M3 Junction 9 Improvement

Scheme Number: TR010055

8.6 Applicant Response to Written Summaries of Oral Submissions at Open Floor Hearing 1 (OFH1) (Rev 1) Clean

17 July 2023

DRAWING TITLE  
 FIGURE 2.6 - THE SCHEME: TEMPORARY DIVERSION OF WALKING, CYCLING, AND HORSE RIDING ROUTES APFP REGULATIONS 5(2)(a) DOCUMENT REFERENCE 6.2

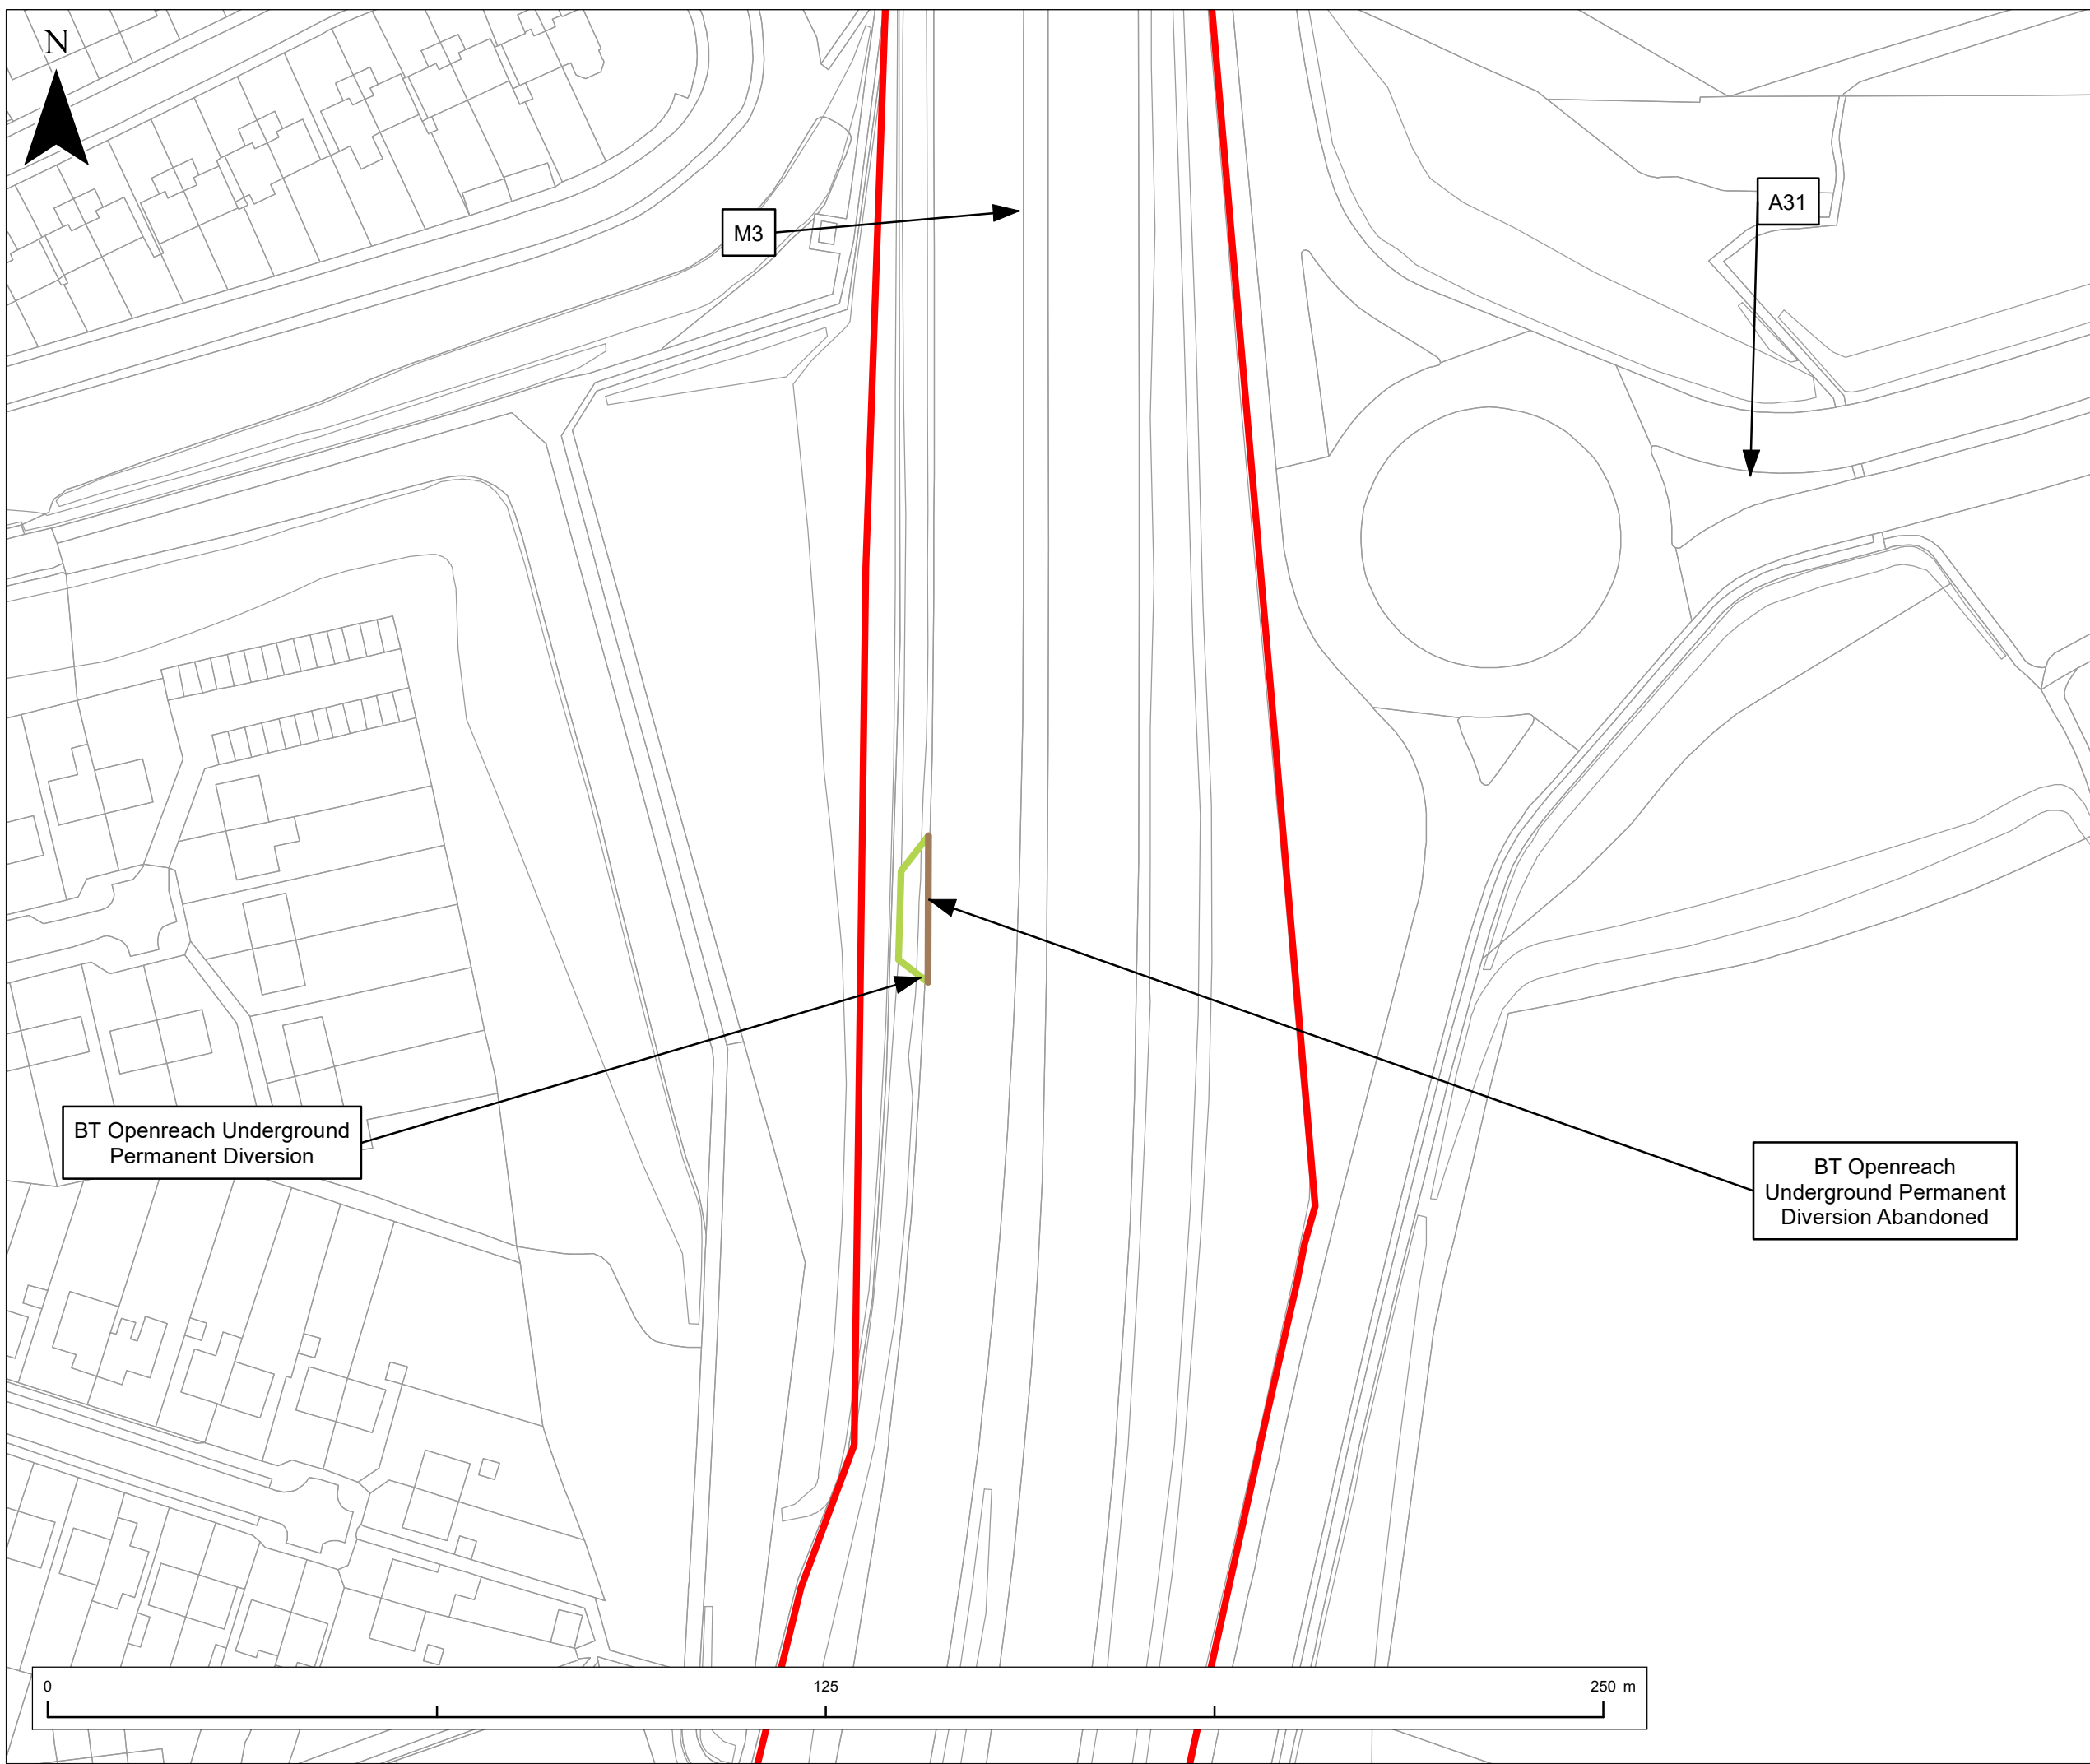
Summary of Oral Representation	Applicant's Response
<p>amount of surface run-off cannot be fully understood.</p> <p>[Extract from General Arrangement Plans provided in REP1-035]</p> <p>The borehole and the infiltration basin are situated at a low point in the landscape and we are concerned that our drinking water supply will become contaminated. The costs and disruption of a new borehole sited away from the basin, or the installation of mains water and future water costs would be considerable.</p> <p>I am concerned about Long Walk being used for access by works traffic. [REDACTED] are accessed only via Long Walk, a narrow lane which includes a bridge beneath the M3. The resident [REDACTED] is very concerned about the impact the works will have on her property. Several PRow converge near Fulling Mill (Itchen Valley Footpaths 20, 21, 22, 49, 52 and Restricted Byeway 19) and during works access will be restricted. Several of these paths are currently in need of maintenance. Once the new bridleway opens these paths should see increased use and will need to be improved and maintained accordingly.</p>	<p>With regards to light pollution, Chapter 7 (Landscape and Visual) of the Environmental Statement (ES) (6.1, Rev 1) considers the effects of light pollution during both construction and operation of the Scheme. As stated in the first iteration Environmental Management Plan (fiEMP) (7.3, Rev 2): <i>'There will be static lighting points fixed to temporary structures such as the masts, cabins, workshops, gantry cranes and silos with the lamps up to 10m in height. These will be used to illuminate regularly used work areas, the car park and access areas. Baffles will be installed on all lighting columns and light is to be angled to face works.</i></p> <p>It is the Applicant's understanding that the borehole detailed as Mansard House is the location referred to by Ms Rosewell, near to the Shoulder of Mutton Farm off Easton Lane. This borehole for private groundwater abstraction is shown on Figure 3.14 'Licenced and private abstractions and SPZs' of Appendix 13.2: Hydrogeological Risk Assessment (6.3, APP-144) and is 90m east of the Application Boundary. The borehole is up the hydraulic gradient of the proposed works which means that groundwater flowing past Drainage Basin 5 will be flowing away from the borehole. It is therefore considered to have a negligible risk of impacting it.</p> <p>Walking, cycling and horse-riding route closures and associated diversions would be avoided unless absolutely necessary. However, due to the nature of the work required on the M3 Junction 9 gyratory, there would be a diversion required to the National Cycle Network (NCN) Route 23 as the new gyratory abutments are constructed. Please refer to Figure 2.6 (Temporary diversion of walking, cycling and horse-riding routes) of Chapter 2 (The Scheme and its Surroundings – Figures (Part 3 of 4)) of the ES (6.2, APP-063) which shows two temporary diversion routes for NCN 23.</p>
